East Anglia ONE North and East Anglia TWO Offshore Windfarms

Applicants' Comments on Natural England's Deadline 8 Submissions

Applicant: East Anglia TWO and East Anglia ONE North Limited
Document Reference: ExA.AS-4.D9.V1
SPR Reference: EA1N_EA2-DWF-ENV-REP-IBR-001035

Date: 15th April 2021
Revision: Version 1
Author: Royal HaskoningDHV

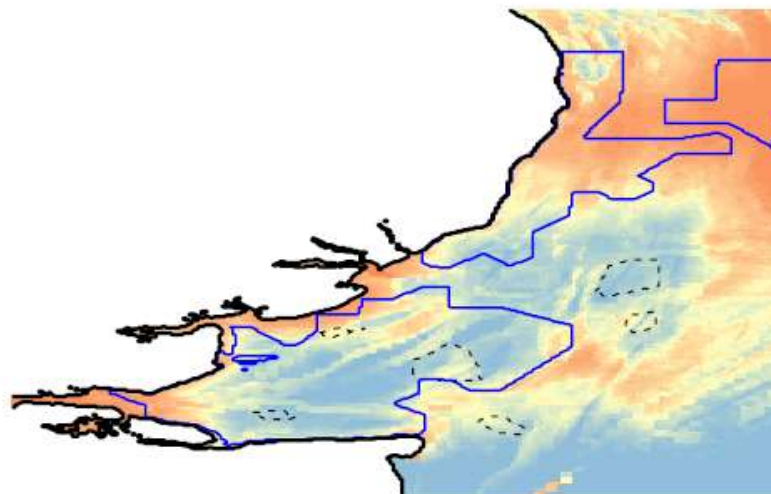
ID	NE Comment	Applicants' Comments
11	<p>10. The lower densities of RTDs within windfarm footprints is clearly demonstrated in the bottom right image in Figure 8, and the largest density of divers is equidistant from the three windfarms – London Array, Kentish Flats and Gunfleet Sands.</p>	<p>As noted above, the apparent displacement effect due to the windfarms was in fact present in advance of the windfarms being constructed and it is therefore not appropriate to ascribe the 2018 distribution of red-throated divers to windfarm displacement, with other factors in the environment already influencing the bird's distribution.</p> <p>It should be stressed that the Applicants are not suggesting that windfarms have no effect on this species, but rather their influence should be viewed in the context of existing distributions and not overstated. This was the rationale for the spatial modelling undertaken by the Applicants, and the use of counterfactual outputs which incorporate existing distributions.</p>
